KITTITAS COUNTY FIRE MARSHAL'S OFFICE

Re: Armstrong (BL-12-00017)

After conducting a review of the above named project, I have the following comments:

Proposed

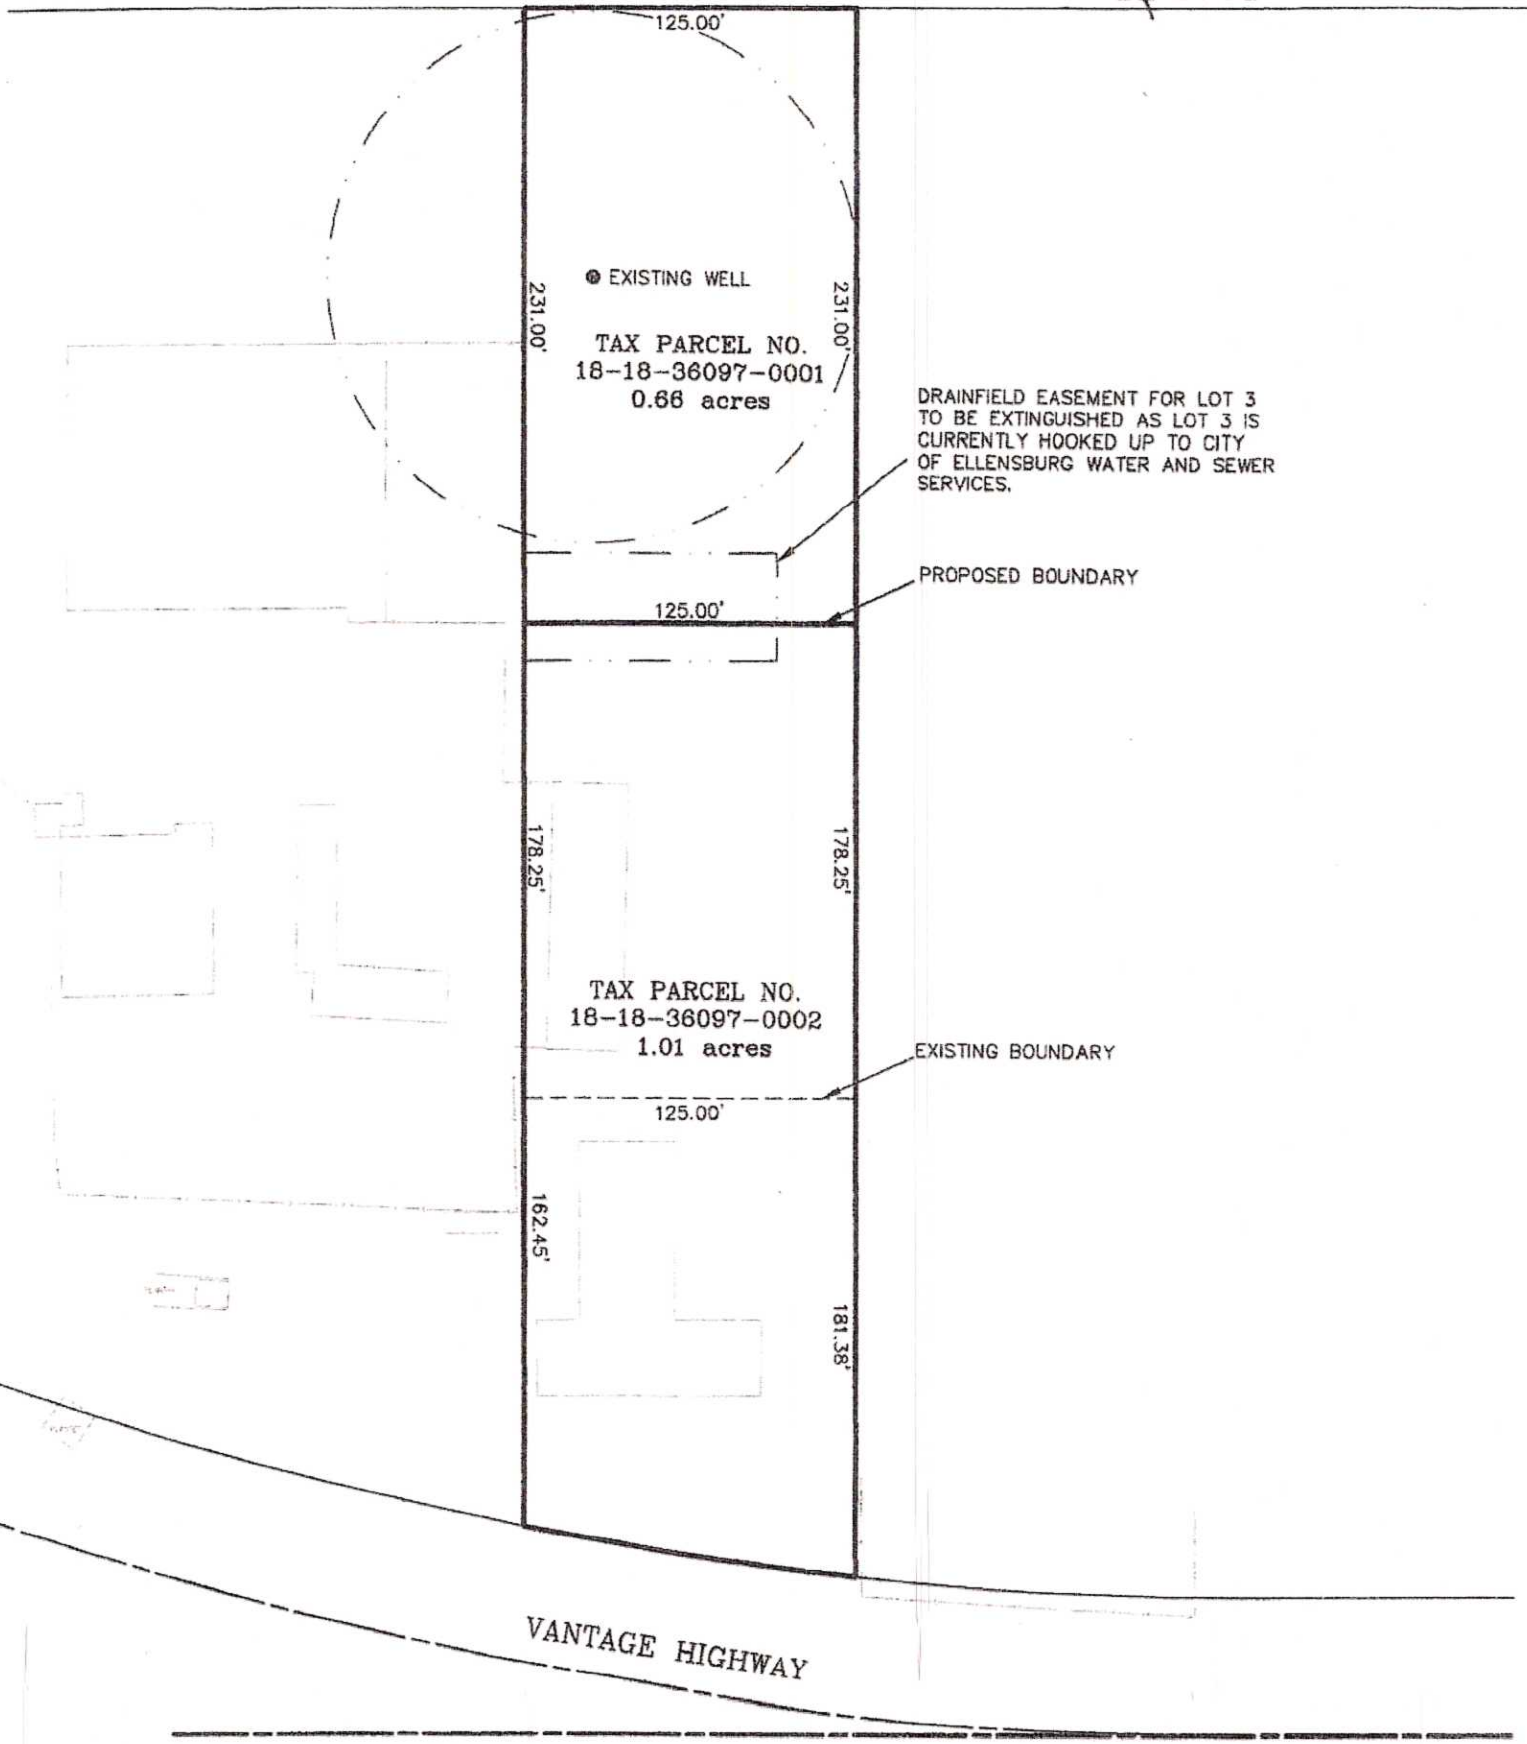
- Ensure that boundary line adjustments do not infringe upon existing structures, to include propane tanks, etc.
- All future development must comply with the International Fire Code.
